# CITY OF ALBUQUERQUE

**Re: Residence INN & Food Hall**  
**1111 Central Ave. NE**  
**Traffic Circulation Layout**  
Architect's Stamp 06-18-24 (K15-D034D)

Based upon the information provided in your submittal received 06-20-24, the above referenced plan cannot be approved for Building Permit until the following comments are addressed:

SITE DETAILS

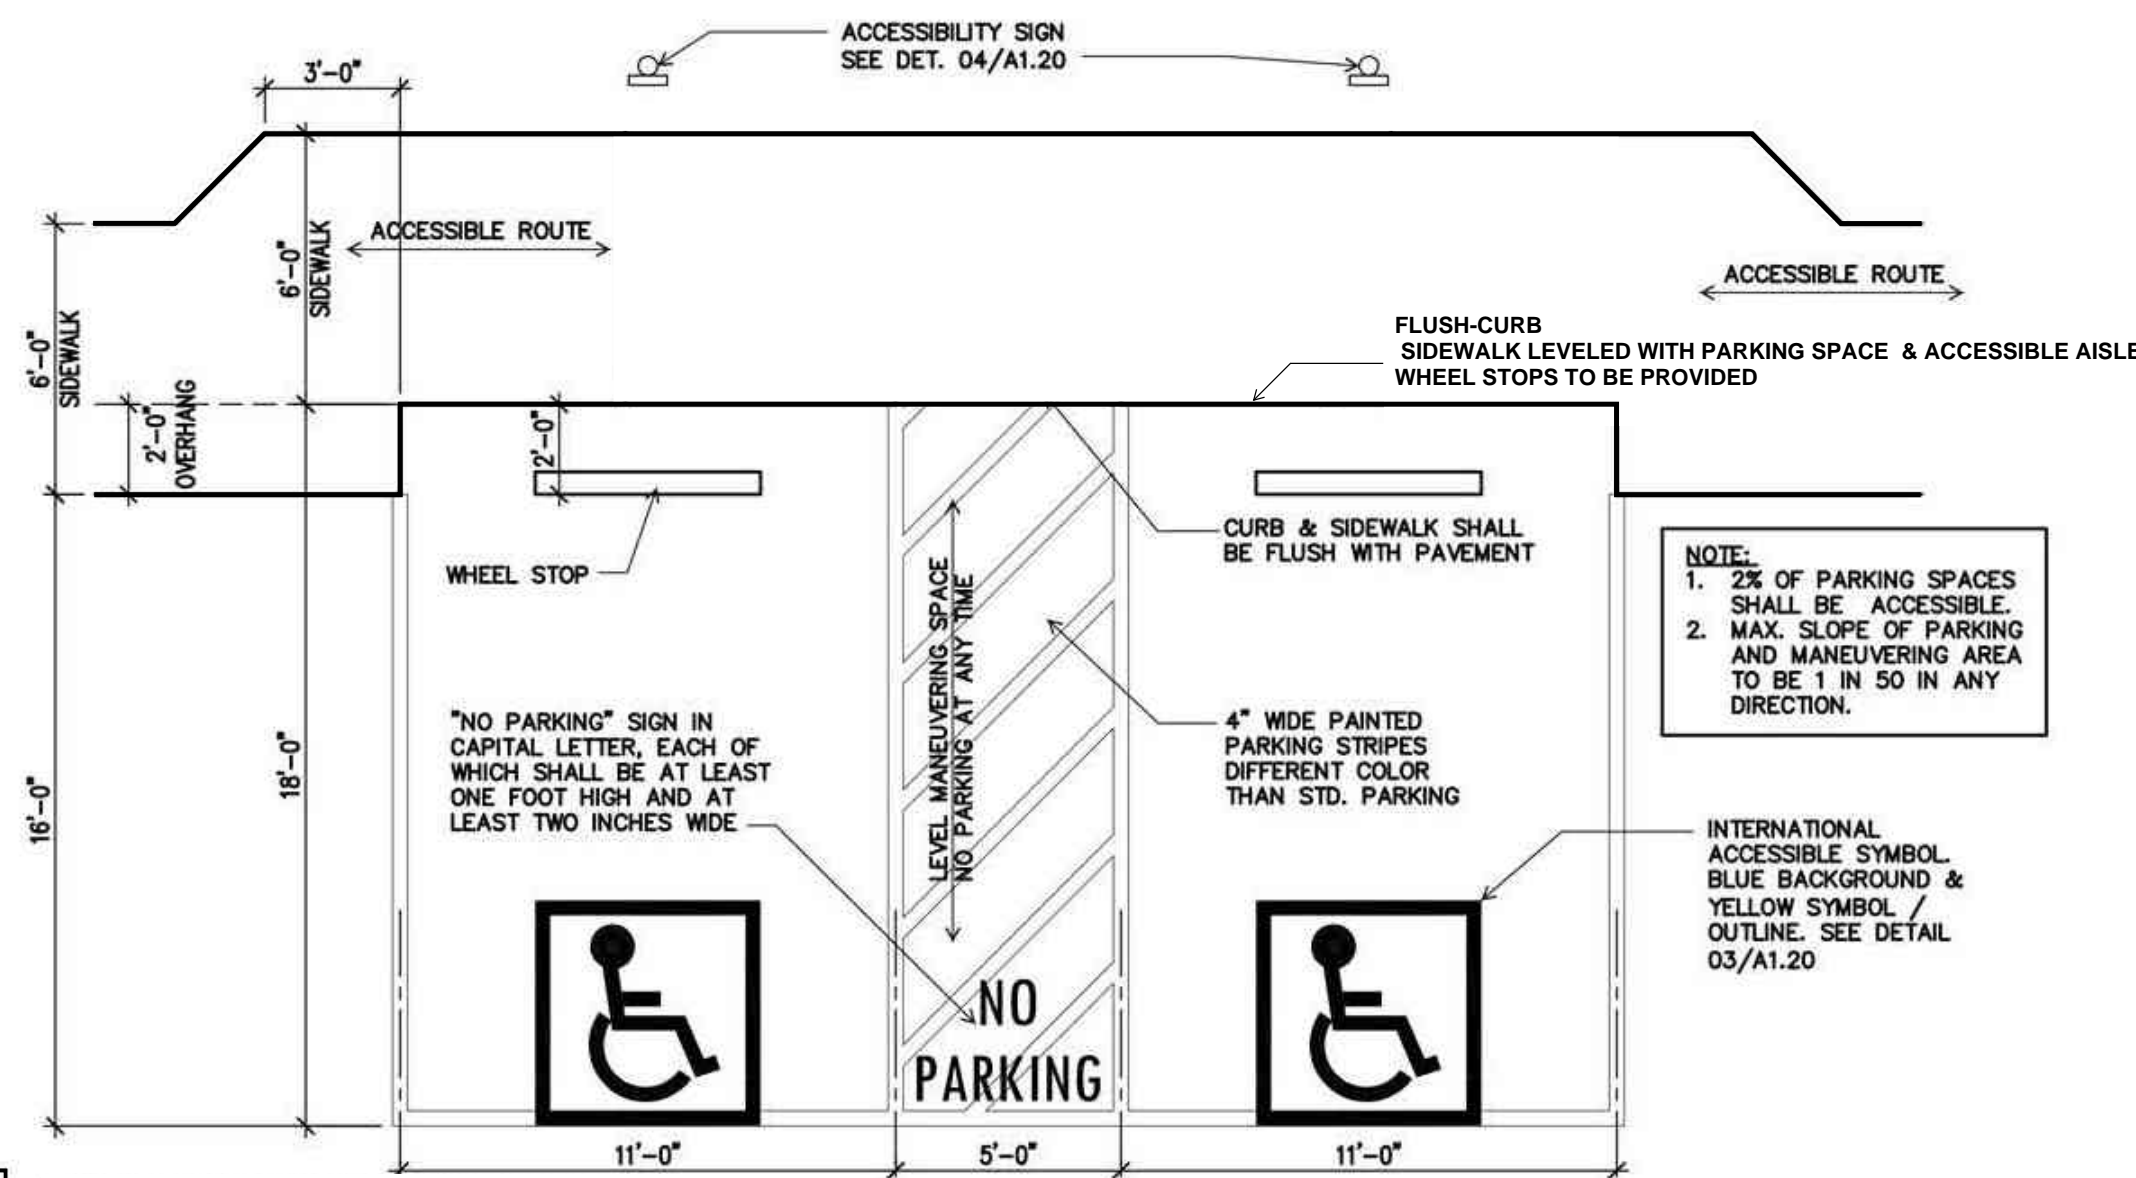
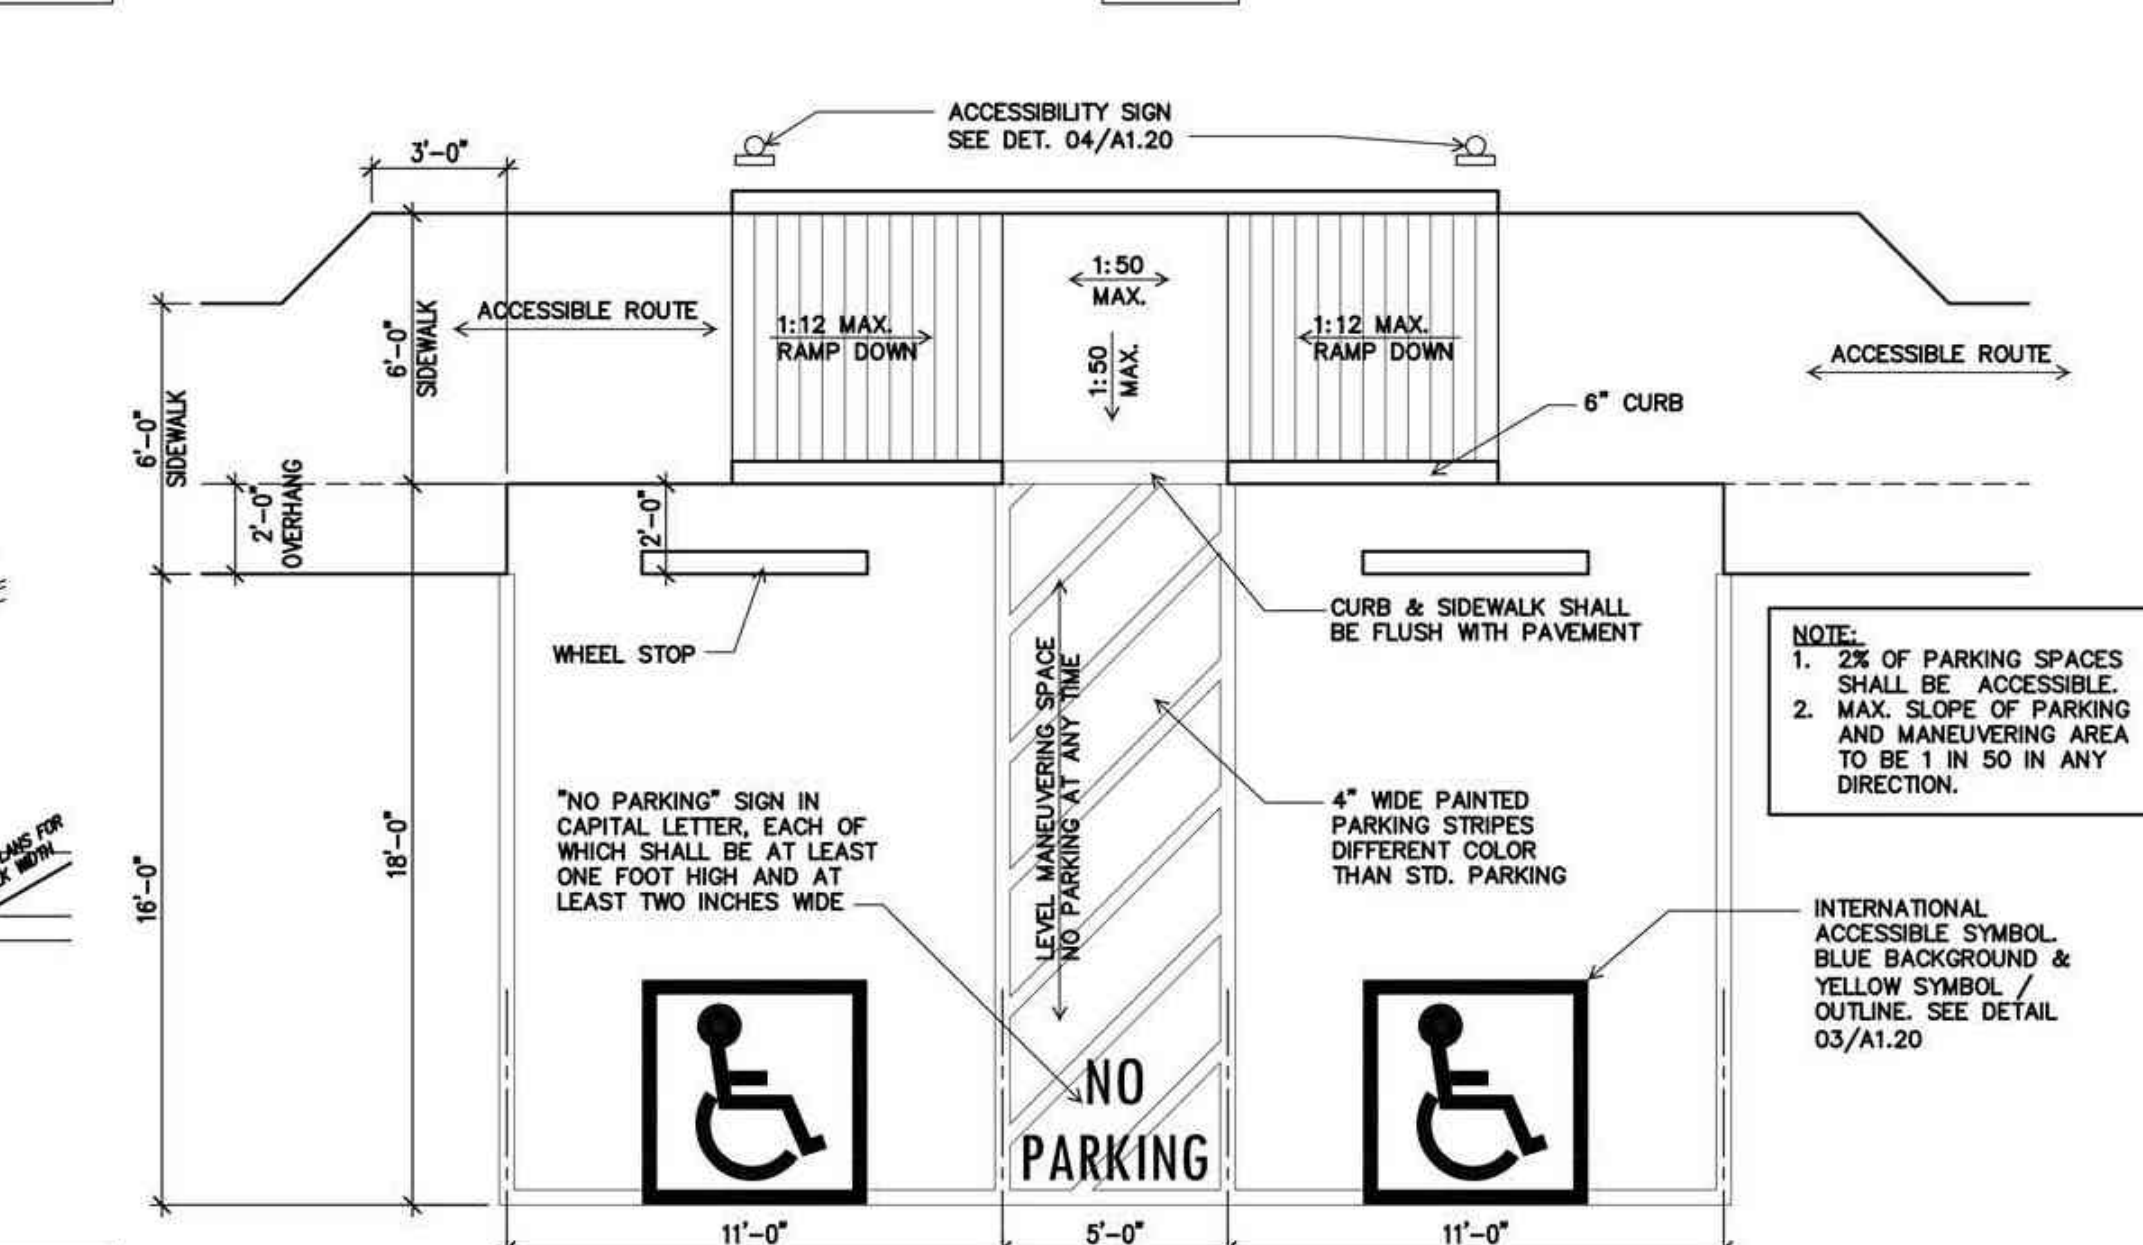
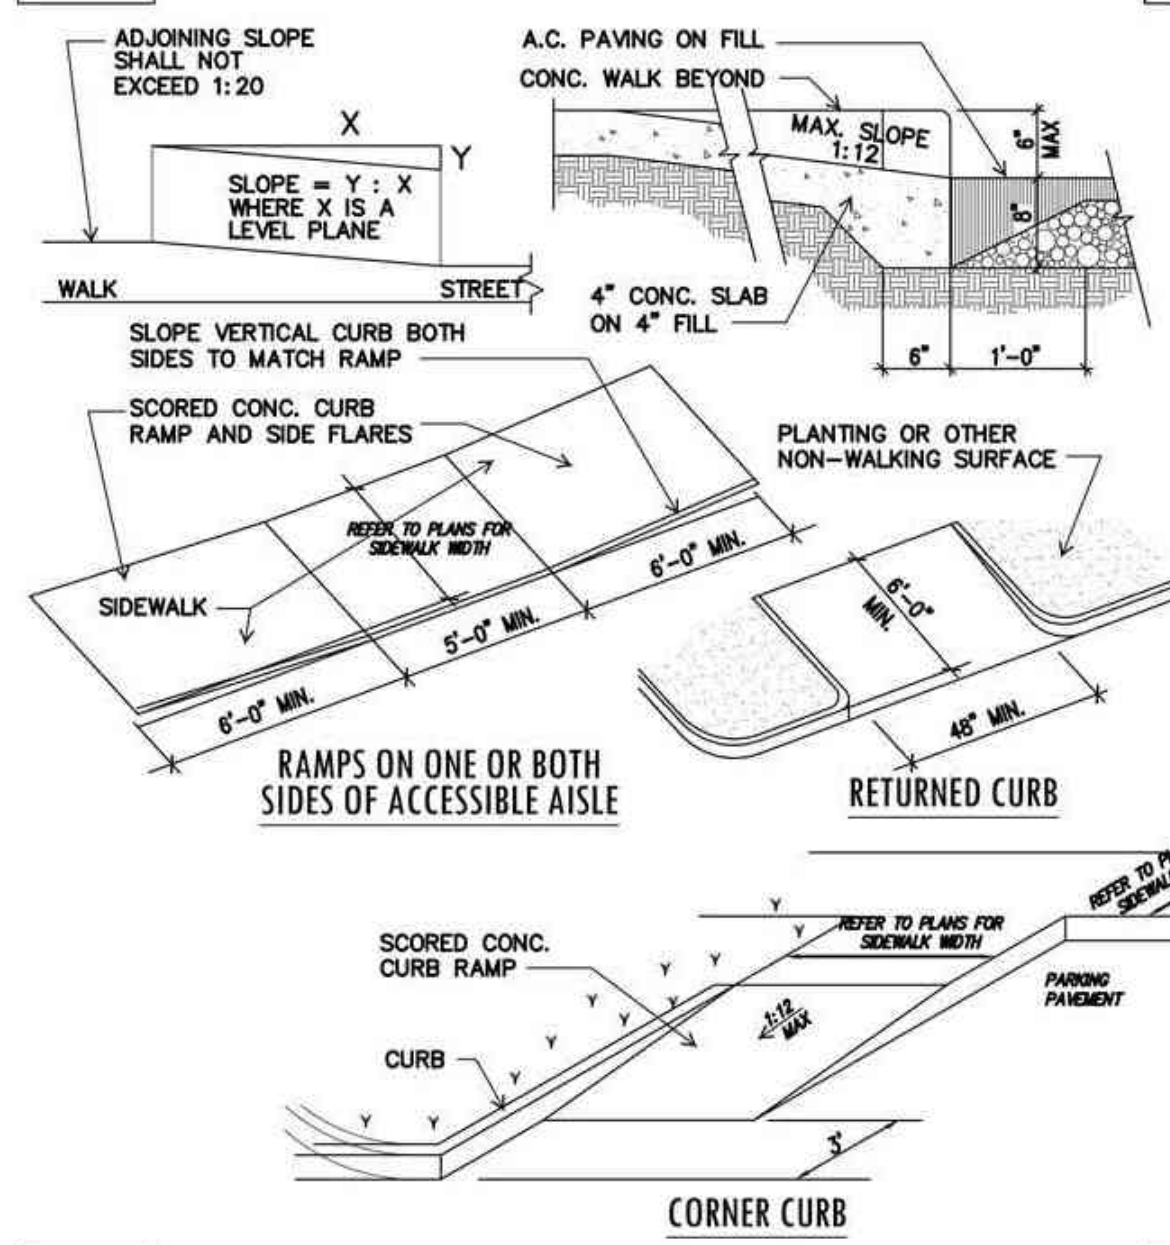
1. Please show on the site plan the proposed 24 offsite parking spaces.
2. Please clarify, is the sidewalk off Copper Ave. going to be demolished?
3. ADA curb ramp at the corner of Cedar St. and Copper Ave. must be updated to current standards and has truncated domes installed.
4. Site access off Central: Please show a proper access point throat length on the site plan. To ensure safety, the ADA parking aisle cannot be placed too close to the access point
5. Please revise the site plan, some of the keynotes are missing, for example: the definition of keynote 12 is missing and the location of keynote 8 is incorrect.
6. Keynote 3: the minimum ADA parking space width is 8.5 ft.
7. Please list the width and length for all proposed parking spaces. Some dimensions are not shown.
8. The minimum parking stall dimensions are:

Type of parking	Min. Width	Min. Length	Min. Overhang
Standard	8.5'	18'	2'
Compact	7.5'	15'	1.5'
Motorcycle	4'	8'	N/A
ADA	8.5'	18'	2'

9. Label the compact parking spaces by placing the words "**COMPACT**" on the pavement of each space.

10. Per the IDO, a 6 ft. wide ADA accessible pedestrian pathway is required from the public sidewalk to the building entrances. Please clearly show this pathway and provide details.

11. Per DPM, a 6 ft. wide ADA accessible pedestrian pathway is required from **each** ADA parking stall access aisles to the building entrances. Please clearly show this pathway and provide details.
